Engineers Comments Regarding Surface Water Drainage

APPLICATION NO: M/15/20/DOC

Site Address: 7 Hadley Close Middleton on Sea

Description of Works: Approval of details reserved by condition imposed under M/29/19/HH relating to condition 5-surface water details

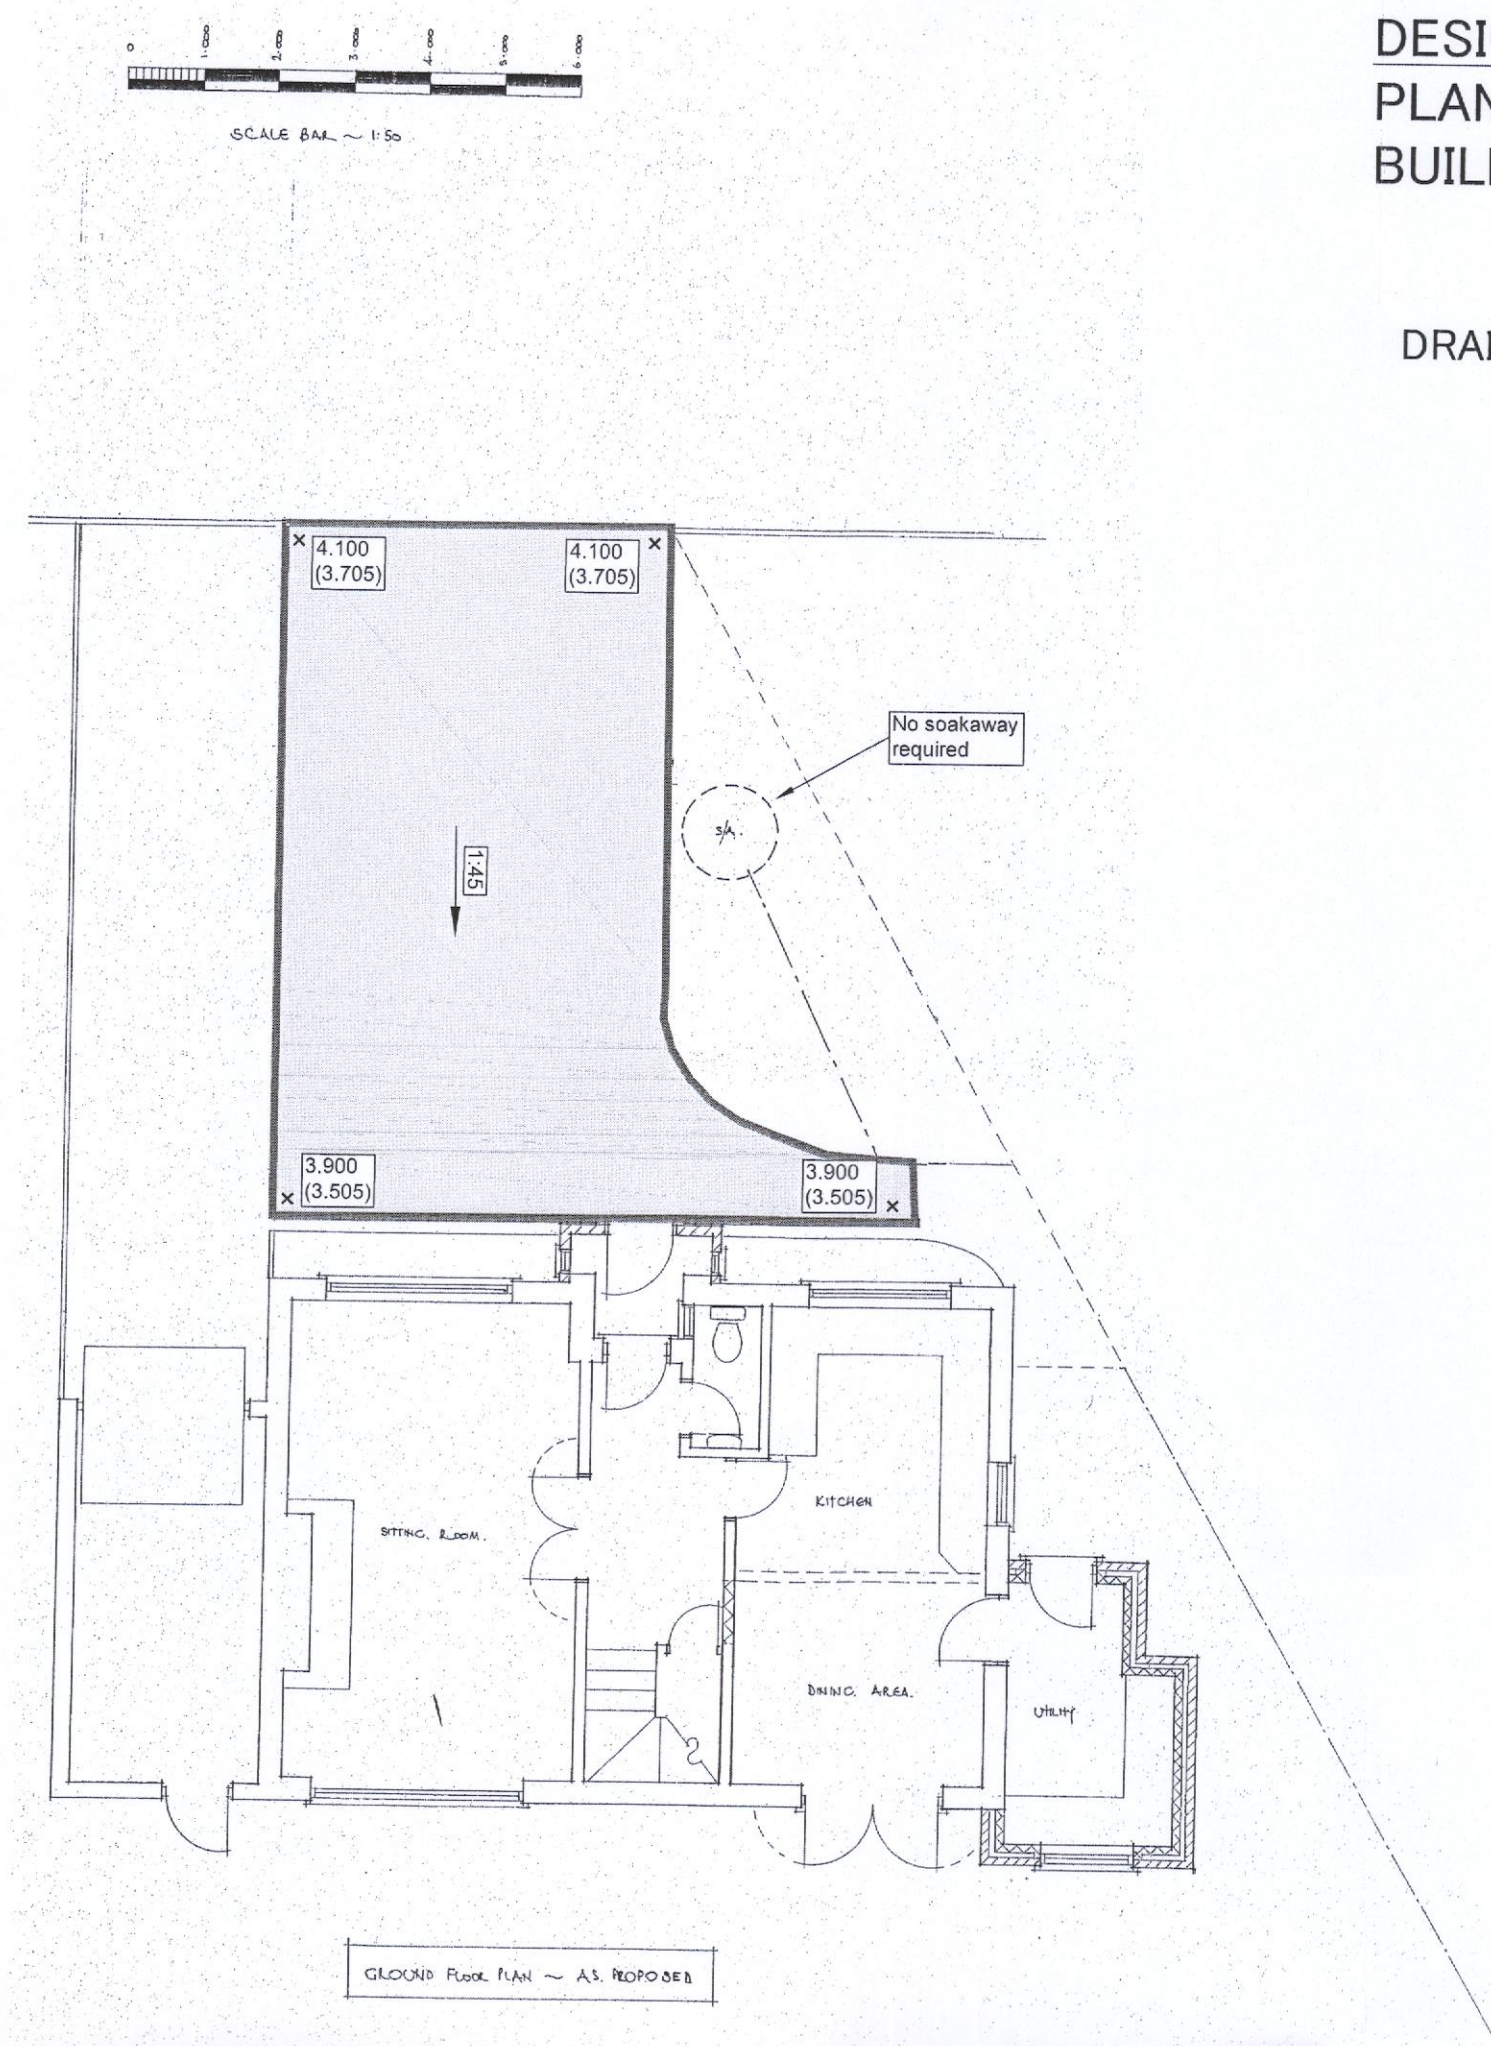
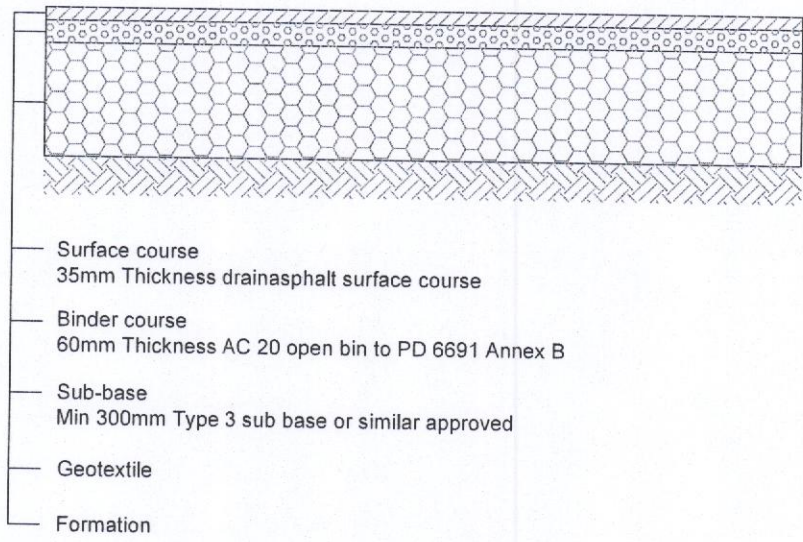
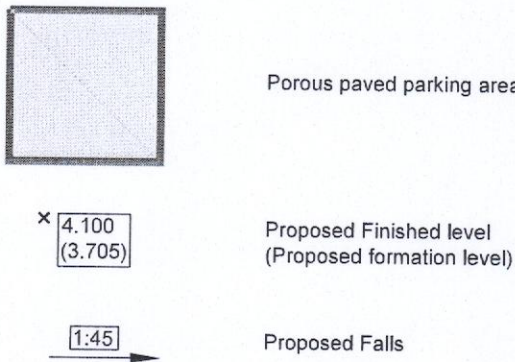
The Drainage Layout shows the location and levels of the permeable paving. Concerningly this appears to show both the finished and formation levels falling at a gradient of 1:45 towards the property. This would result in water flowing towards the building which may compromise the foundations. It is suggested that the formation levels are adjusted to ensure that water flows away from the property, if this is not possible an alternative solution may be required to ensure the stability of the building.

Furthermore, it is understood that the permeable paving is proposed as an alternative to a soakaway, to drain both the driveway itself and the proposed extension and porch. Yet the drainage layout shows no connection of the porch and extension to the permeable paving. However, the calculations **do** appear to account for these additional impermeable areas.

1. The fall of the formation level towards the property.
2. Connection of the proposed extension and porch to the permeable paving via diffuser unit(s) located 5m from the building if possible.
3. Silt trap to be included for surface water entering from the extension and porch.
4. Invert levels of pipes and their diameters.
5. Detail of pipe bed and surround including a note of pipe materials.

“Following our conversation earlier, I would like to confirm that I have looked through the records for adjacent properties and it appears that these 1970’s houses were built with foundations over 800mm deep, so in this instance it would be acceptable if there was a slight fall towards the house of the 400mm deep formation level. There is also an area directly against the property itself with no permeable paving where there is presumably a flower bed or similar, so the driveway excavations will not be taken right up to the existing foundations.

With regards to the surface water disposal from the utility room extension, we would expect that whether it is to a soakaway or the permeable paving (with suitable calculations) the discharge point from the roof drainage was 5m from any buildings. If the roof drainage is taken into the permeable paving it is common to see the pipe discharge to 1 soakaway crate within the permeable paving.

On this basis I am happy for the formation levels to be left unadjusted.

2) It should be noted the proposed extension on the side elevation will not be implemented, the intention is to connect the rainwater from the porch extension into an existing rainwater downpipe which serves the main house. It is our intention to install a new silt trap to this existing downpipe position.

3) We would confirm therefore that there will be no need for any new drains so Items No's 4 & 5 are not relevant.
